Retention and completion of an agricultural shed and storage/office unit.

Rossadillisk, Co. Galway.

Application for approval made under Section 177E of the Planning and Development Act, 2000 as amended for Substitute Consent.

Inspector Stephen Rhys Thomas.

EXISTING WORKS TO
AGRICULTURAL STORAGE
BUILDING (Scale 1:200)

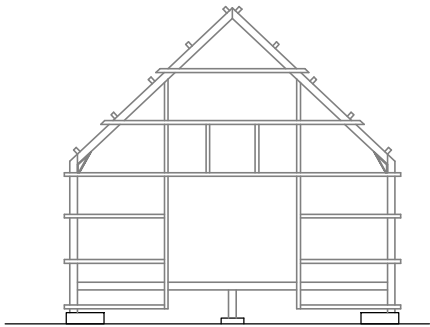
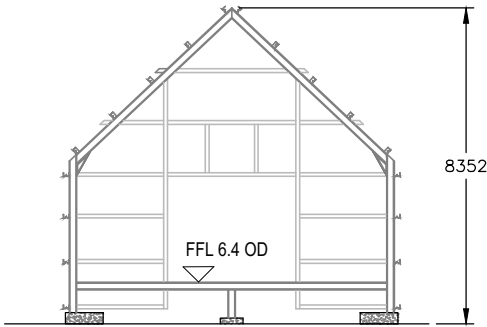
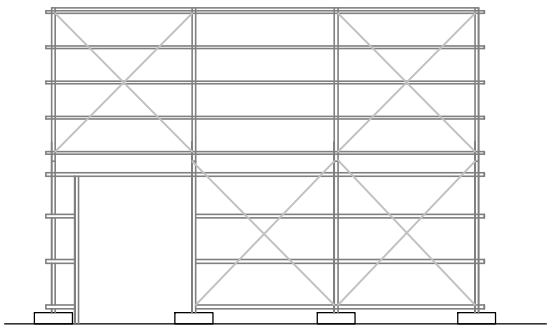
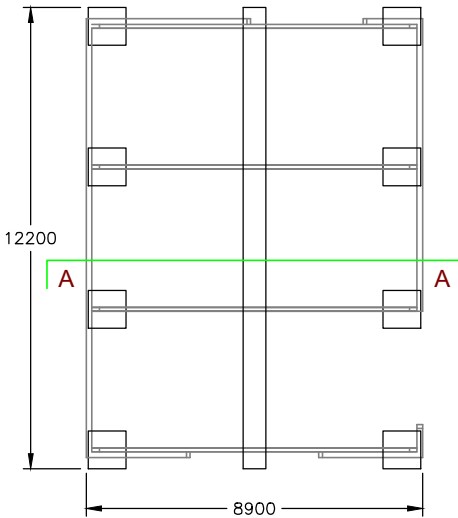
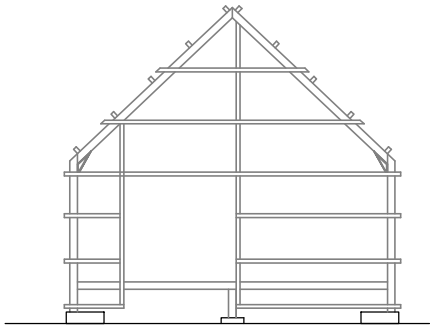
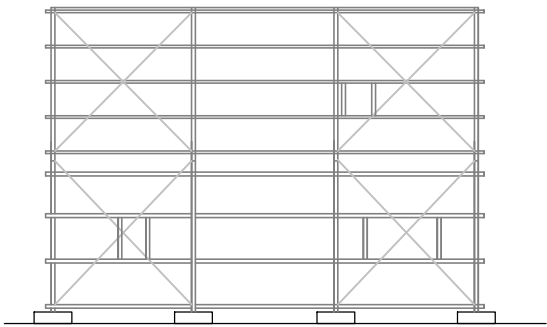
10.3.13. The main impact from the shed as it now stands is its overall height when compared to other buildings in the immediate area. The selection of a dark cladding material is not so intrusive, other roofscapes are dark grey to black and I note that agricultural buildings can vary from dove grey to iron oxide red. The applicant has provided images of other sheds in the area. It is the height of the shed that stands out. Older bungalows in the area tend to be around 5 to 7 metres, but I note new two storey housing on inland sites where heights of up to 8.7 metres may be the case.

10.3.14. It is not necessary for the applicant to prepare a Visual Impact Assessment for this development, after all the shed is almost complete and so the visual impact can be readily ascertained. In this regard, I note the prevailing character of the area, it is coastal, low lying with small amounts of domestically scaled and mostly single storey development. The shed is a new feature on the landscape, but it sits close to the ruins of a former building and so from a purely locational point of view, things make sense. I note a newly renovated vernacular shed in the vicinity and this is a very good way of integrating buildings into a sensitive coastal landscape and is to be commended. The applicant could have done likewise and renovated their buildings on the site, subject to the necessary consent, but they did not. In this regard I note that DM standard 17 states that the conversion of existing farm buildings in rural areas for small scale employment purposes will be considered. The applicant could have been more sensitive in terms of the overall height, but given that the visual impact is limited to the immediate environs, I see no reason to seek its reduction.
